I understand from John Hall that the Jackson Purdue Lever drawings have now been superseded by the Civil Engineering Practice drawings, whereby there are significant changes, so have had to look at things afresh. It is also noted that only the layout drawings have been received ie. no calculations, construction details or management & maintenance manual..

Reservoir Catchment

Please see the string of emails below plus the additional information attached that you requested for the glasshouse & reservoir development at Wicks Farm, Ford.
Don't hesitate to come back to me if you need further clarification on anything.

TYPICAL SECTION SHOWING SWALE 1 PROFILE

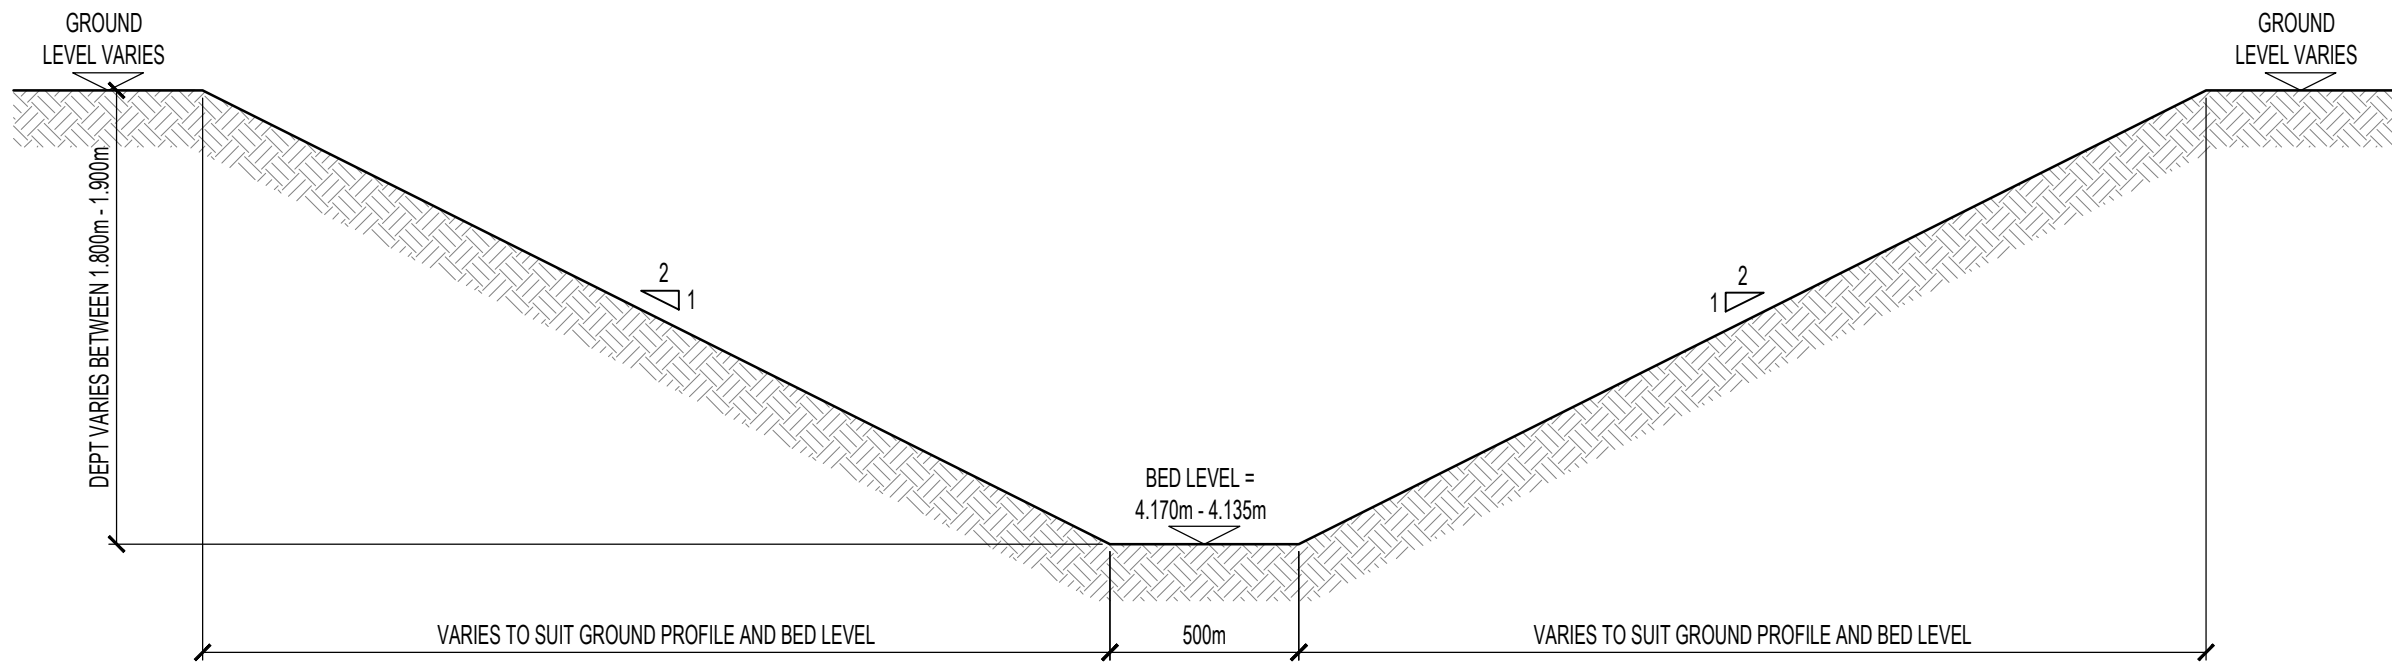
21. Outlets to swale 1 – provide min. 100mm freeboard between swale bed and pipe inverts.

22. Provide positive fall on pond 1 (swale) bed.

Pipe invert specified on drawing allowing for 100mm freeboard within the design between ditch bed and pipe invert as requested.
No further comment.

As noted above, there is infiltration present within the swales therefore no positive fall is proposed or required for the swale bed.
No further comment.

TYPICAL SECTION SHOWING SWALE 2 PROFILE

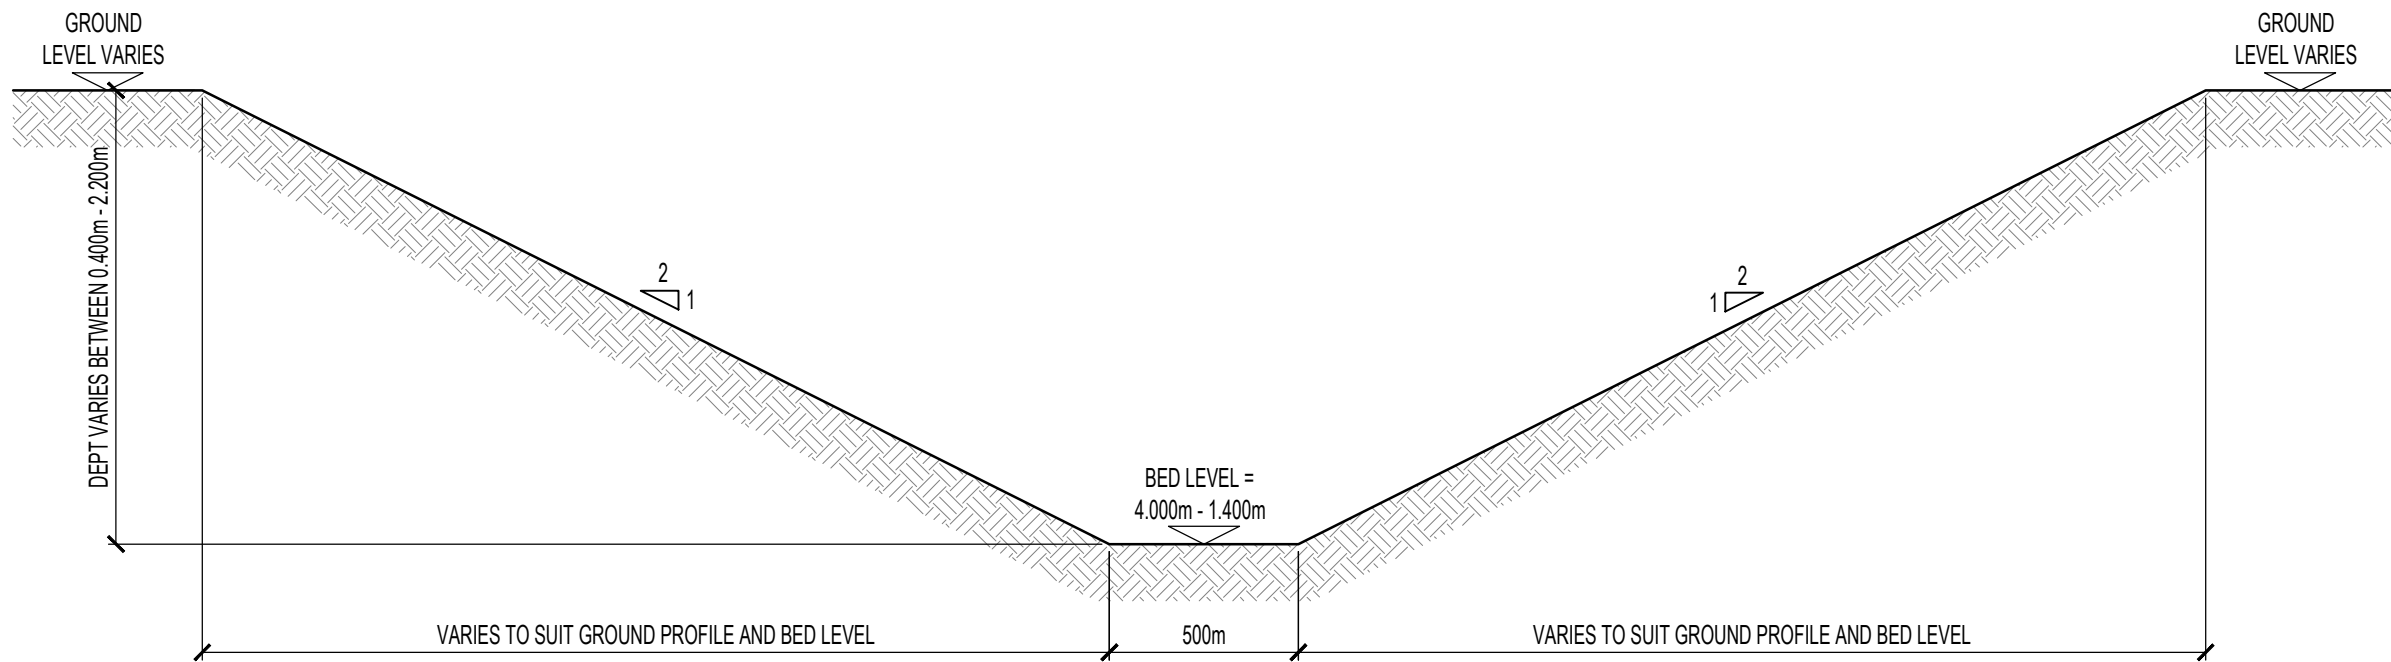
16. Incoming 225mm pipe to swale 2 – provide min. 100mm freeboard between swale bed and pipe invert.

Pipe invert specified on drawing 25 allowing for 100mm freeboard within the design between ditch bed and pipe invert as requested.
No further comment.

TYPICAL SECTION SHOWING POND 1 PROFILE

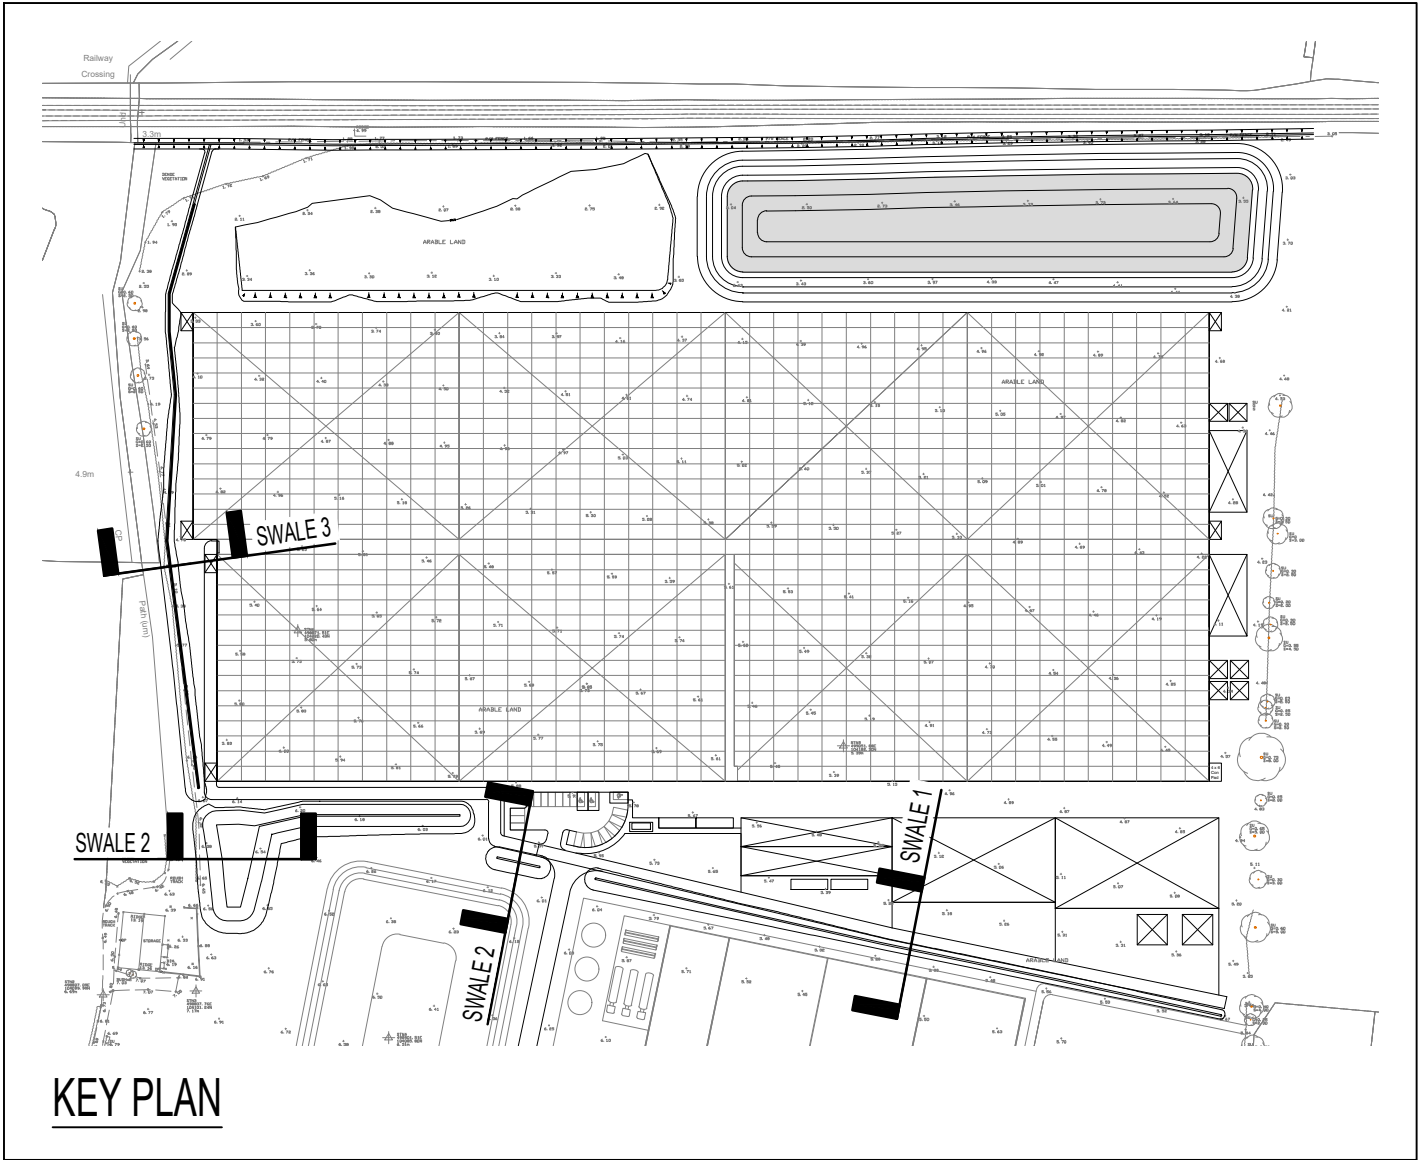
26. Pond 1 and associated swales – show top of bank levels on all sides.

Additional levels have been added to the top of all ponds and swales.
No further comment.

PRIVATE MANHOLE DETAIL TYPE W (WITH CATCHPIT)
DEPTH FROM COVER LEVEL TO SOFFIT OF PIPE 1.0m - 1.5m
INTERNAL CHAMBER DIAMETER 1500mm*
MAX. SEWER DIAMETER 375mm
(SCALE 1:25)

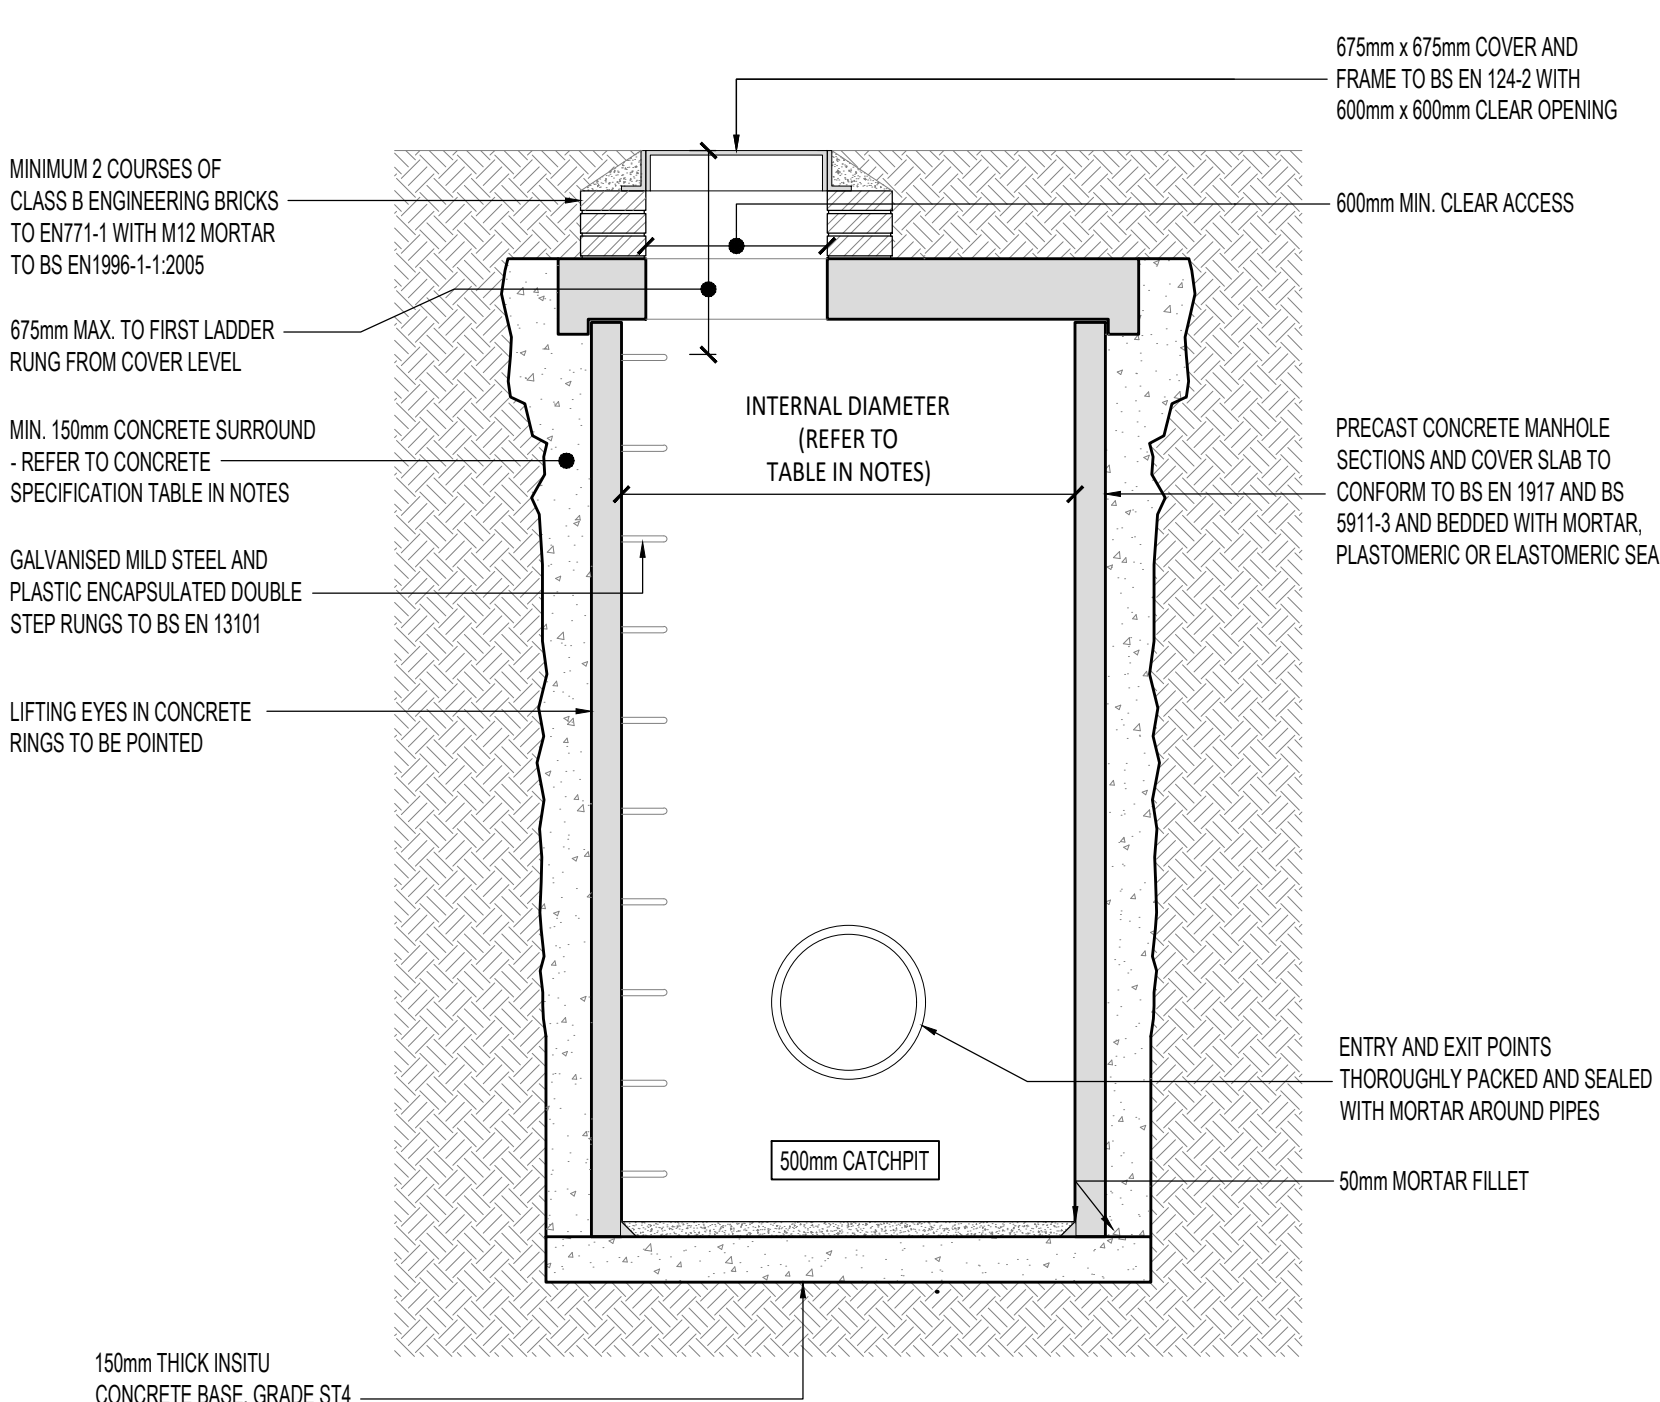
12. Catchpit type W detail – include step rungs for access.

Steps added to catch pit detail on drawing 51.
Step rungs added to our detail also.

TYPICAL PIPE BEDDING AND TRENCH DETAILS

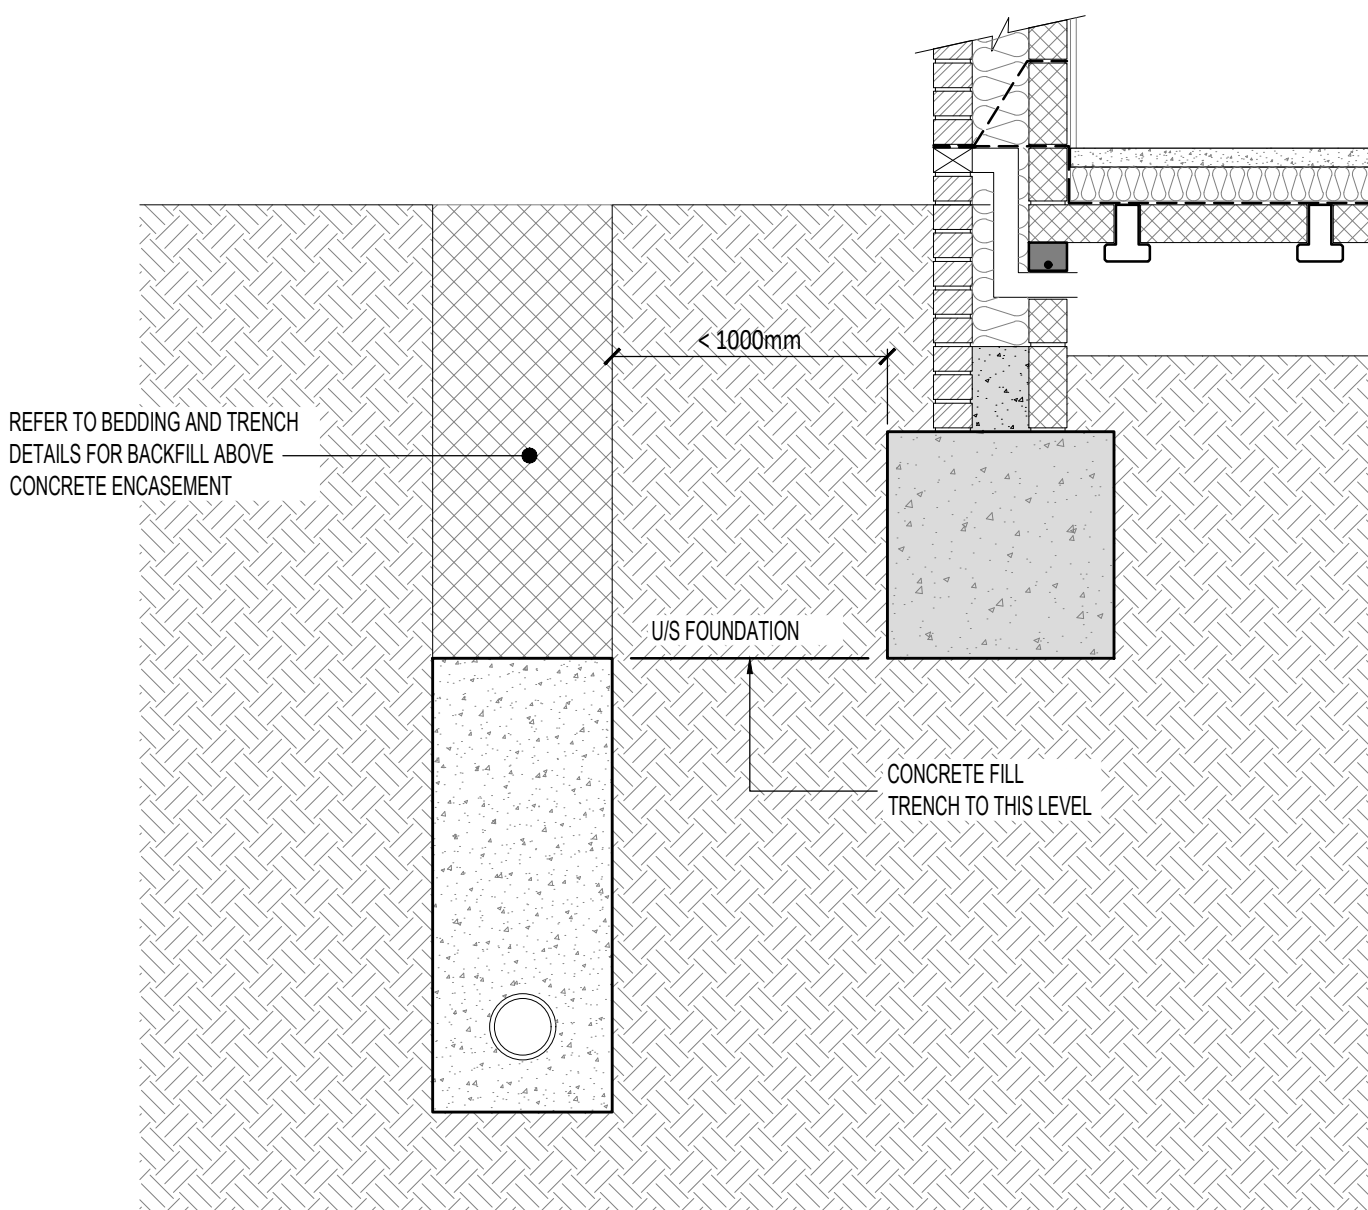
17. Pipe concrete bed and surround detail – specify the specific concrete mix on the detail itself.

Pipe concrete bed and surround detail shown on drawing 51.
Detail already part of information provided.
